Pre-Design Investigation
(Additions)

ADDRESS 7th & MARQUETTE (N.W. CORNER) ZONE ATLAS # K14 J-14/071

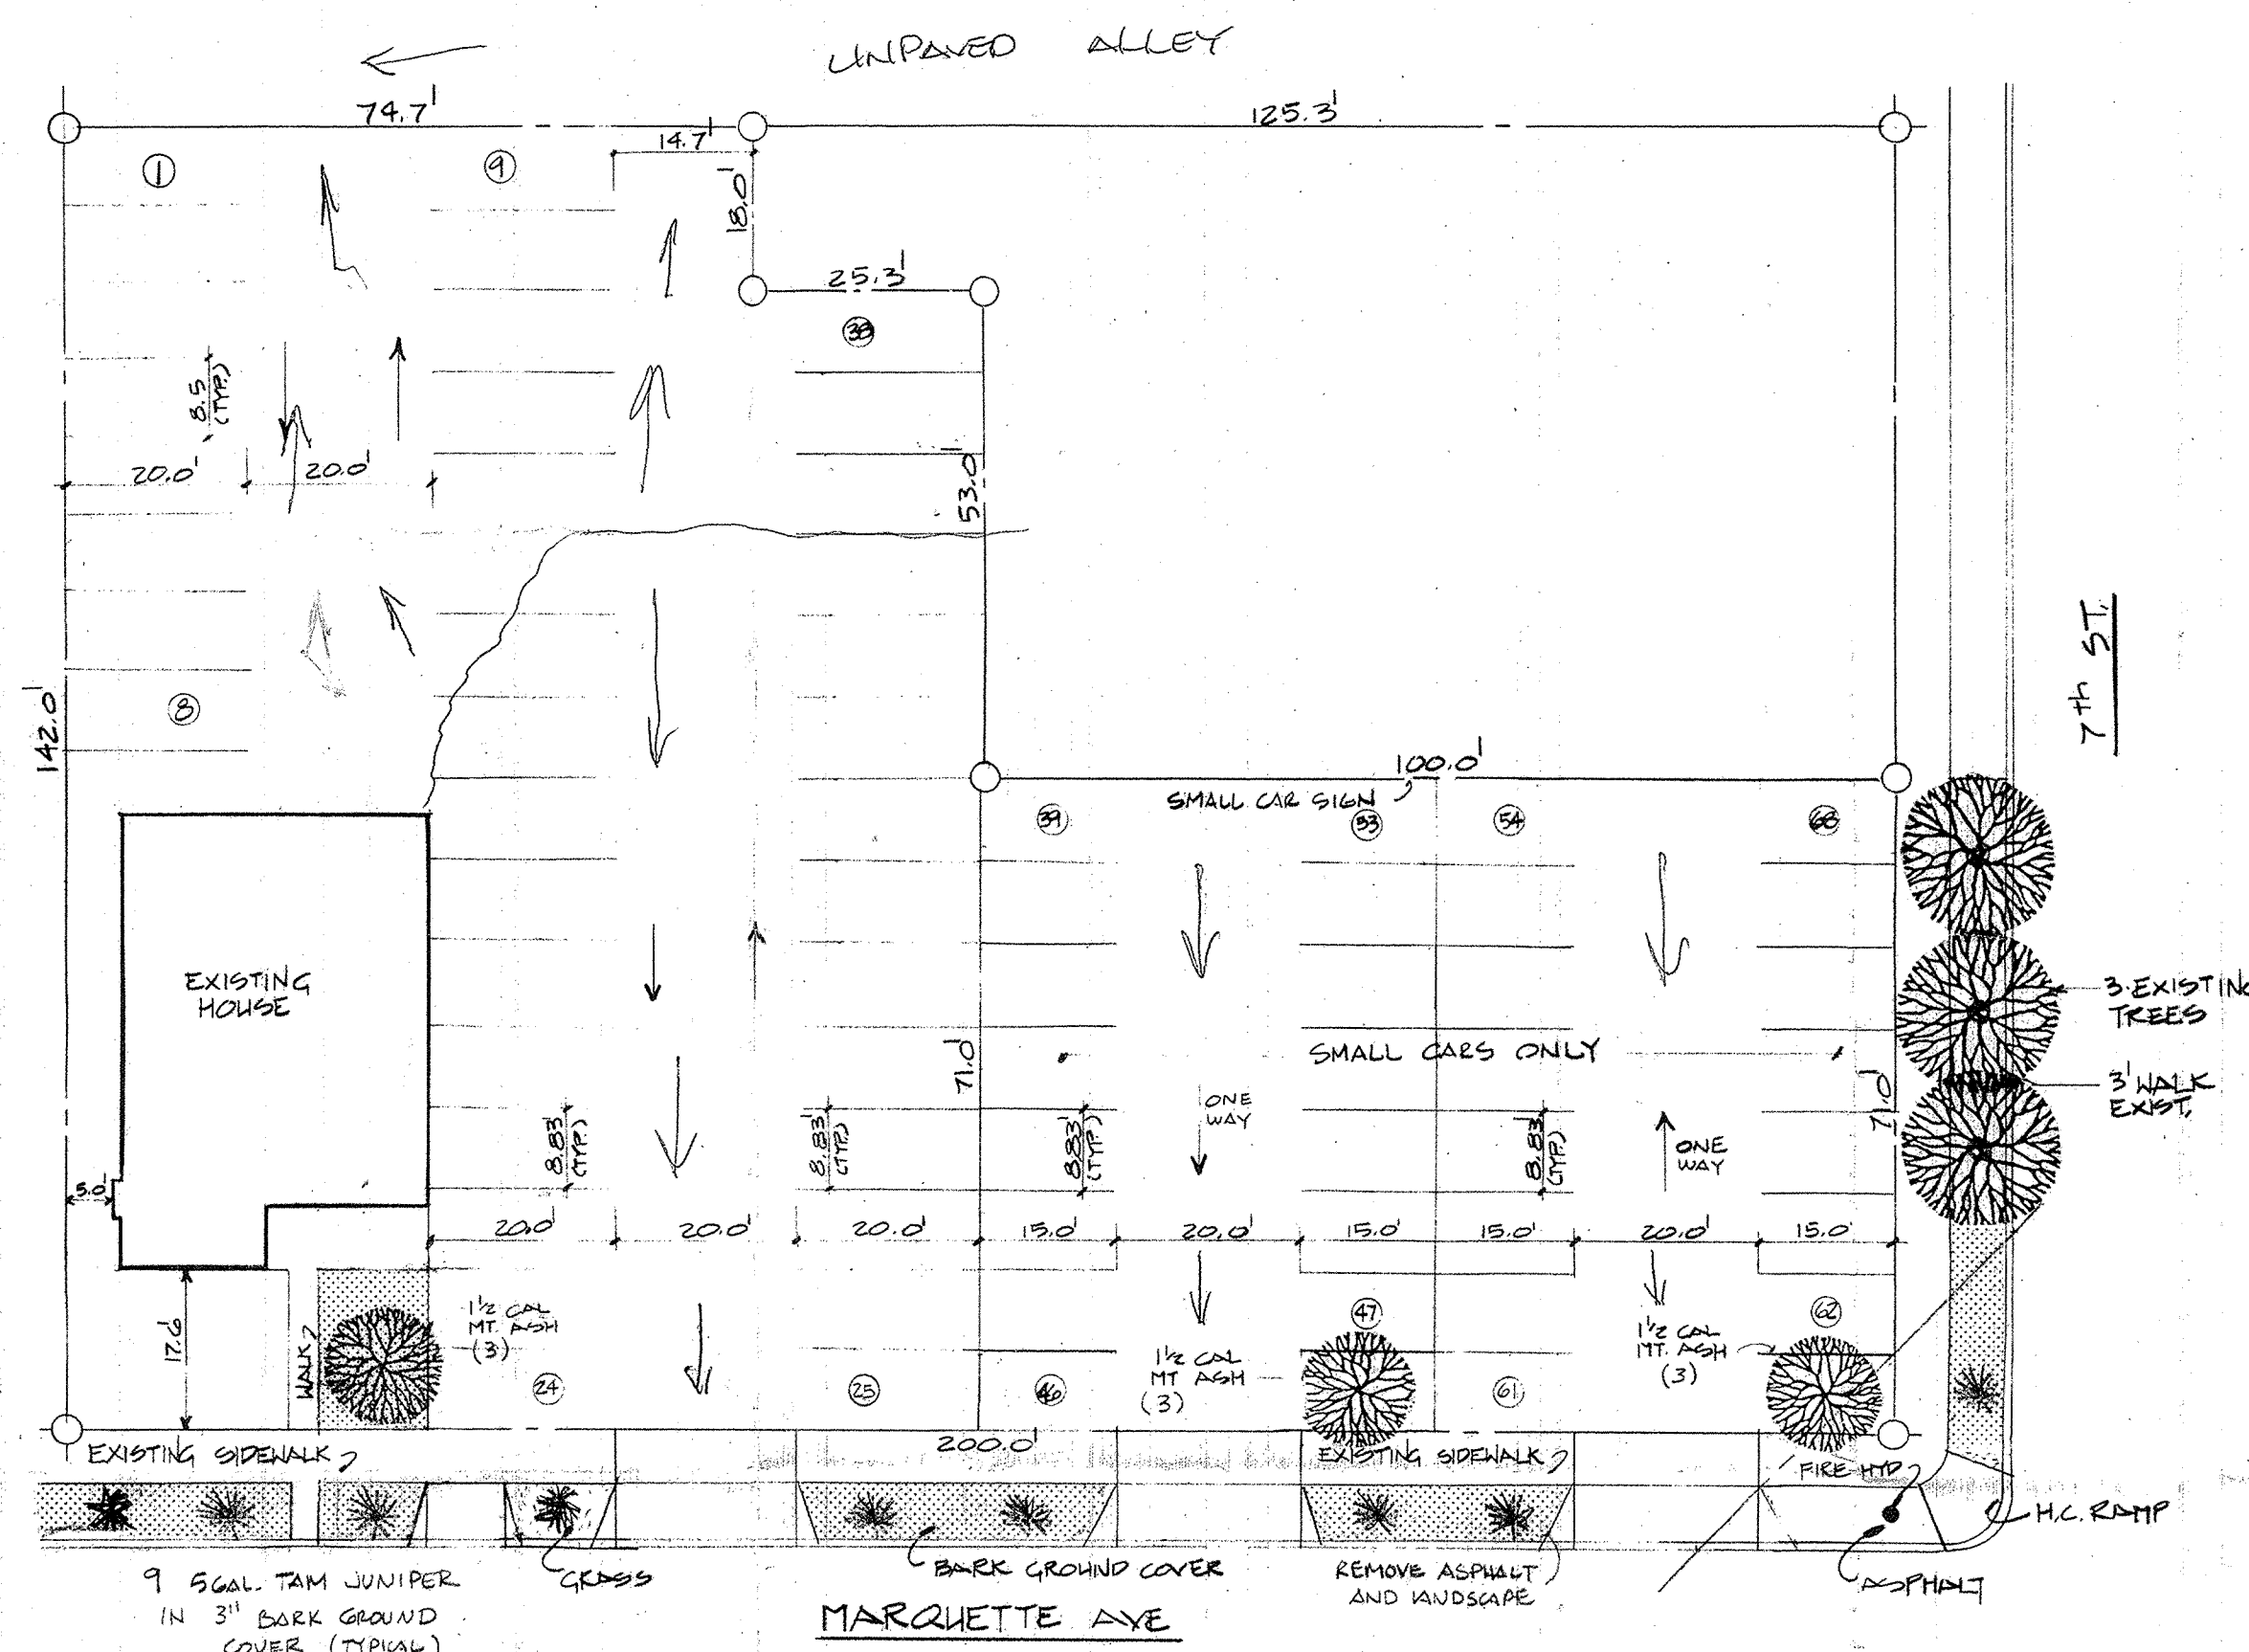
MAJORITY OF SITE DRAINS INTO MARQUETTE
A SMALL PORTION OF SITE "C" N.W. CORNER
DRAINS INTO UNPAVED ALLEY.
